Re: **SSI-9487; Narromine to Narrabri (N2N) Inland Rail Project; PIR Submission**

21 September 2022

APPENDIX A: Issues identified in the PIR

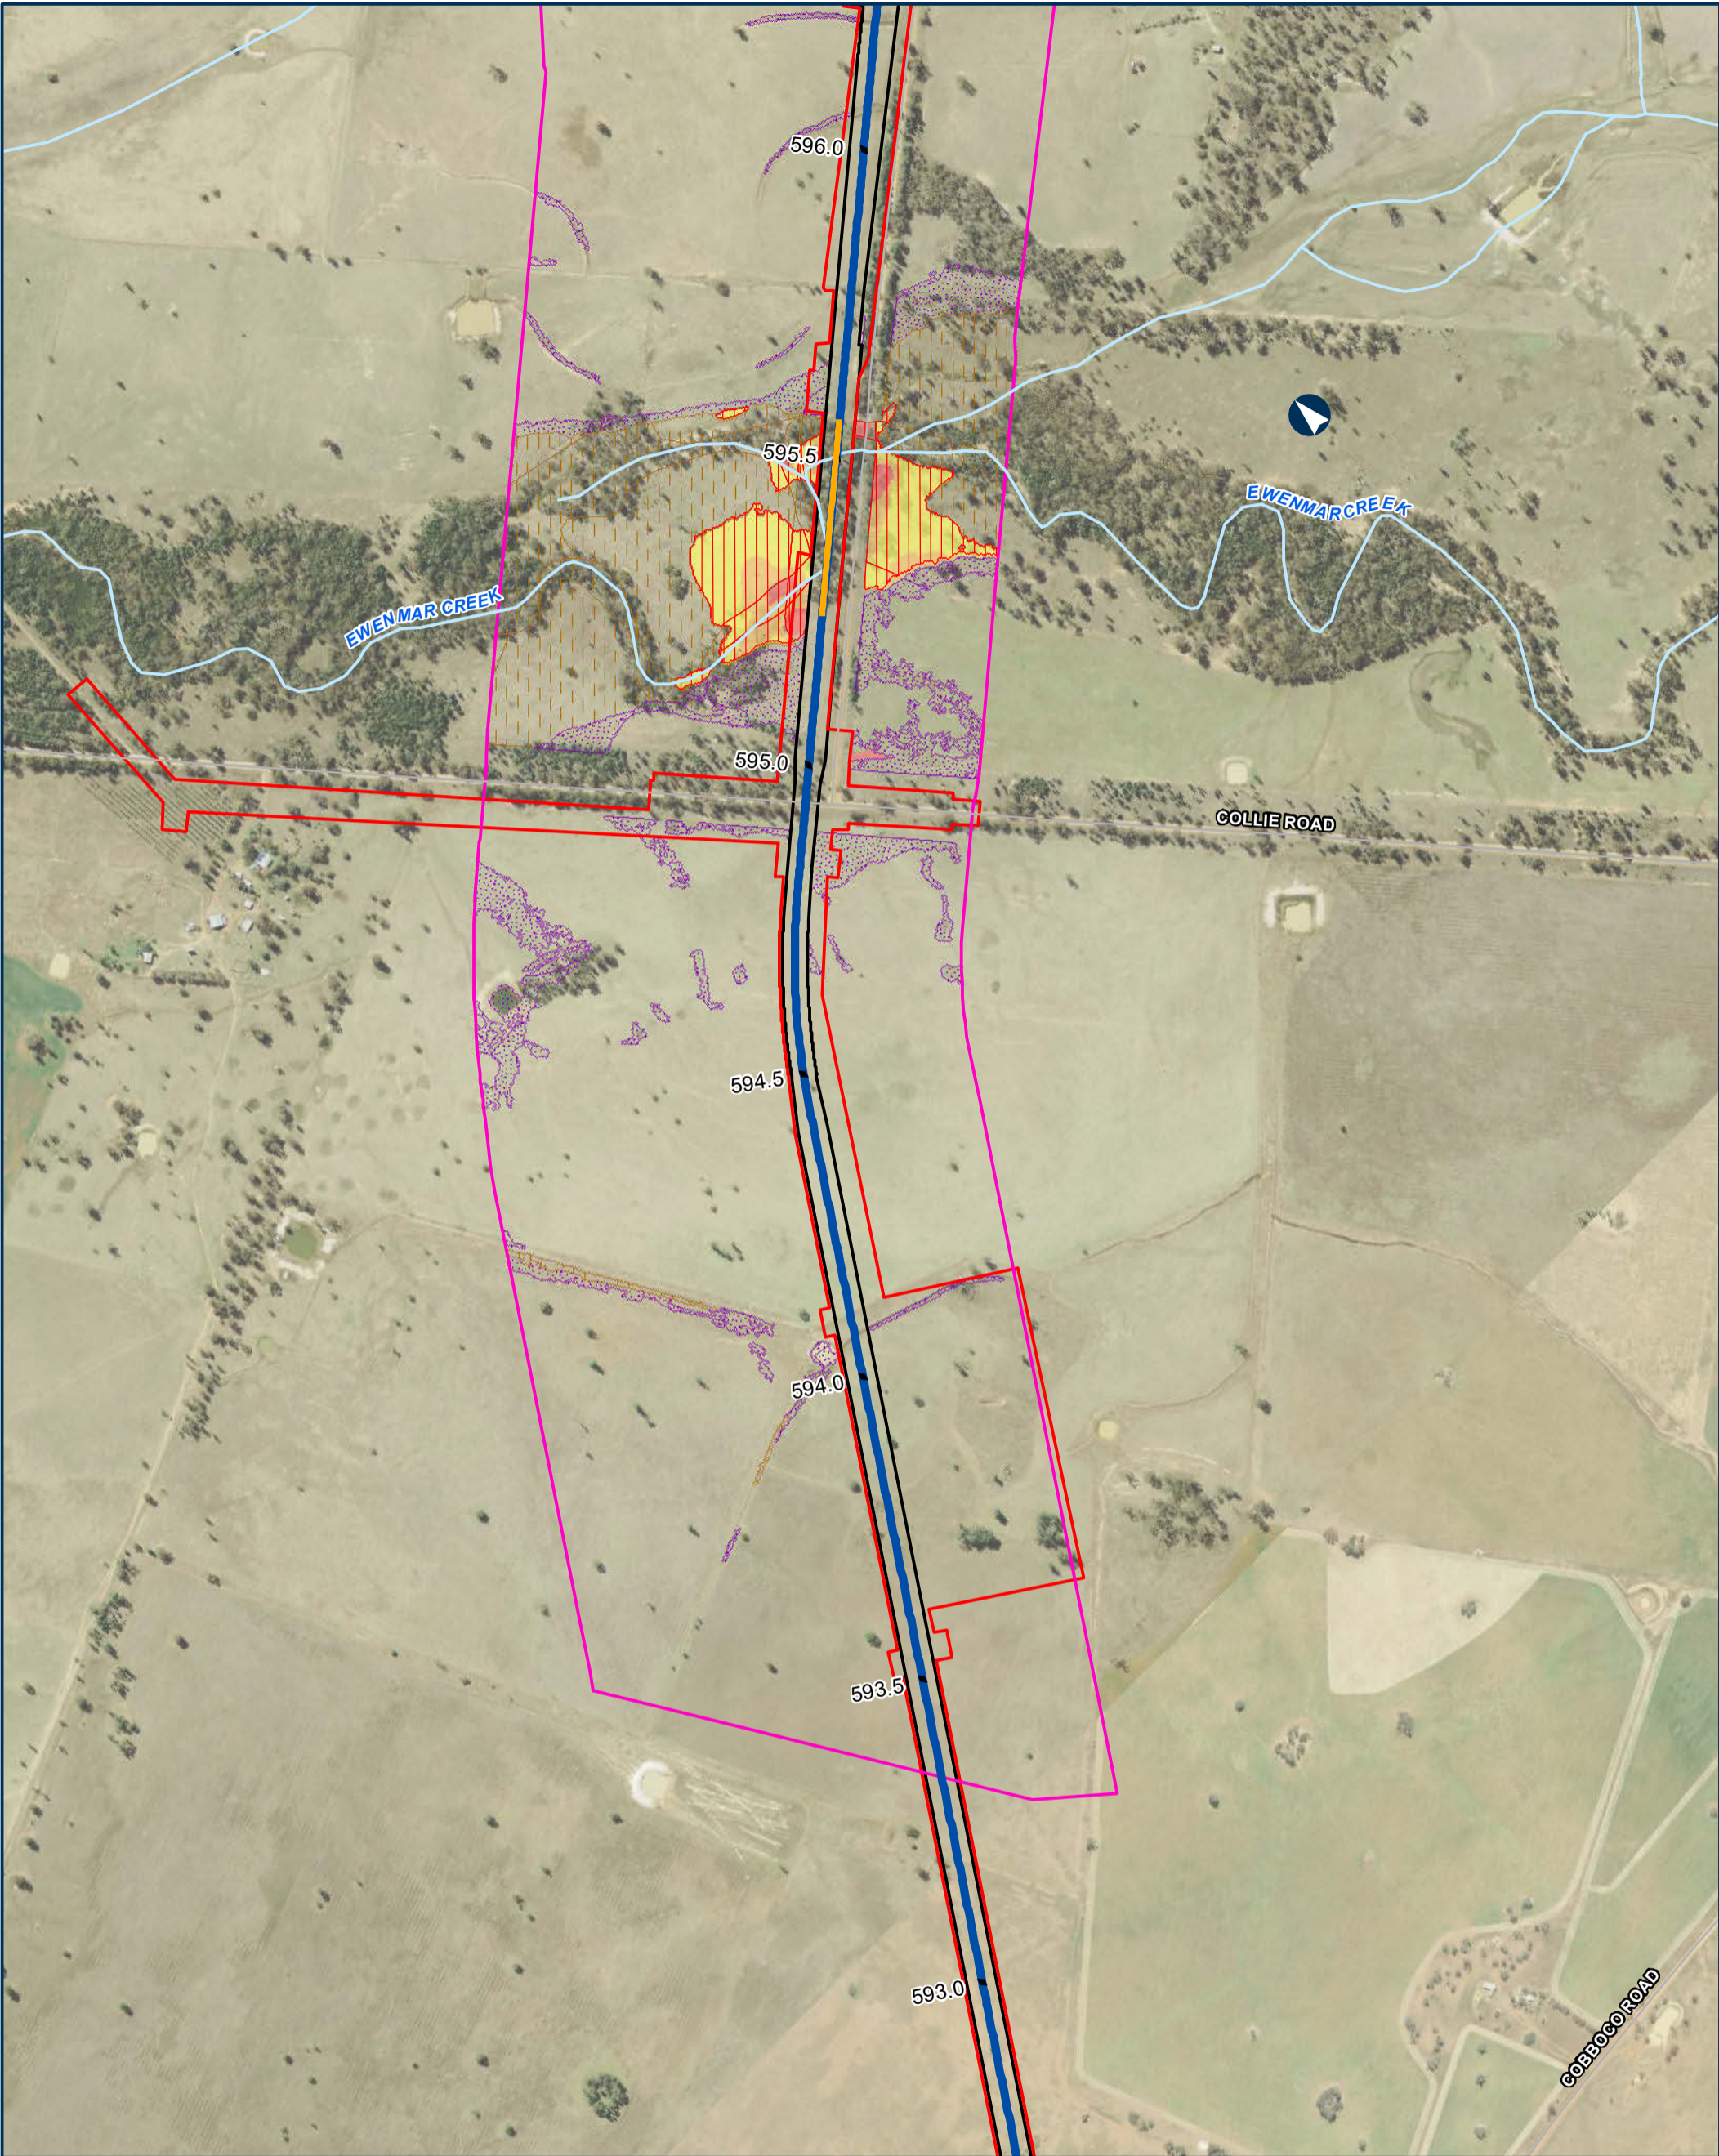
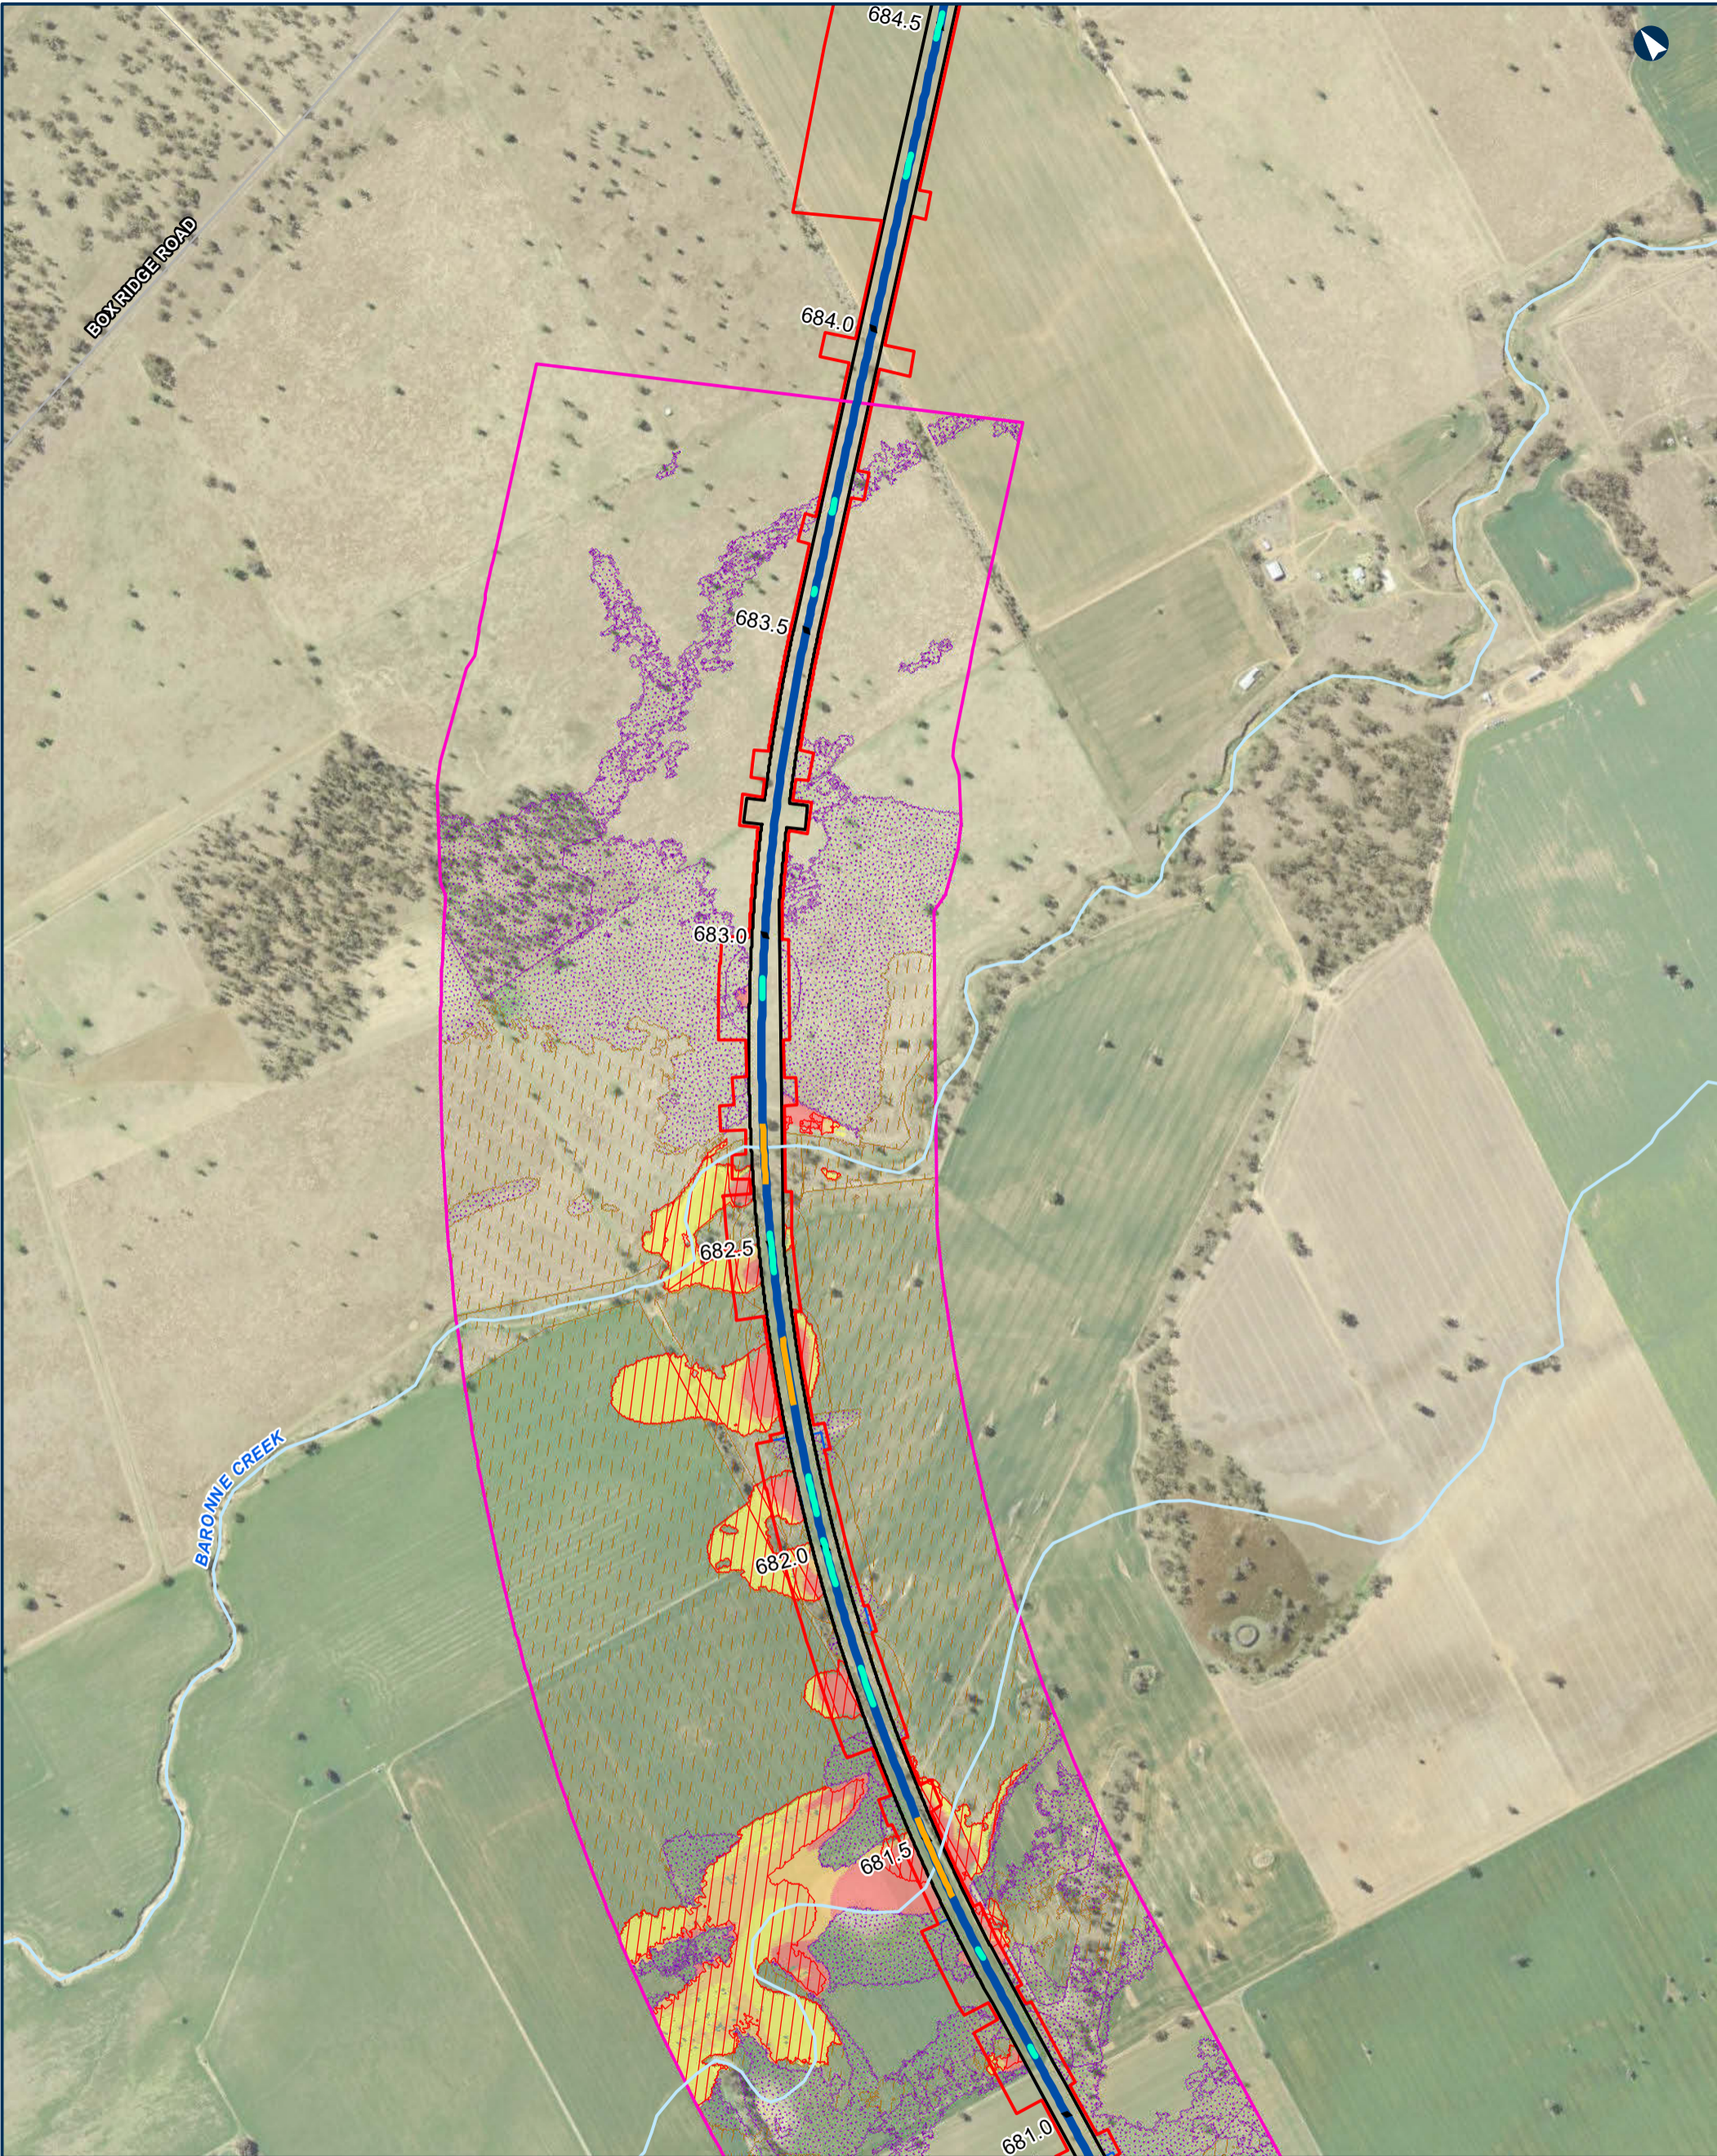
Transport does not accept any new inundation of the State Road Network including the pavement and unsealed or unprotected road edges. Both the EIS and PIR indicate that highways and roads will experience adverse flooding impacts because of the proposed Inland Rail project. ARTC has assumed Quantitative Design Limits (QDLs) based on the adjoining N2NS project. On that project breaches to the QDLs are now requiring extensive mitigation. QDL concessions granted on N2NS where highway upgrades are planned are not applicable to the N2N project. As such, TfNSW objects to the proposal as submitted. TfNSW is willing to reconsider its objection, provided suitable QDLs can be agreed upon that do not introduce new flooding to State assets.
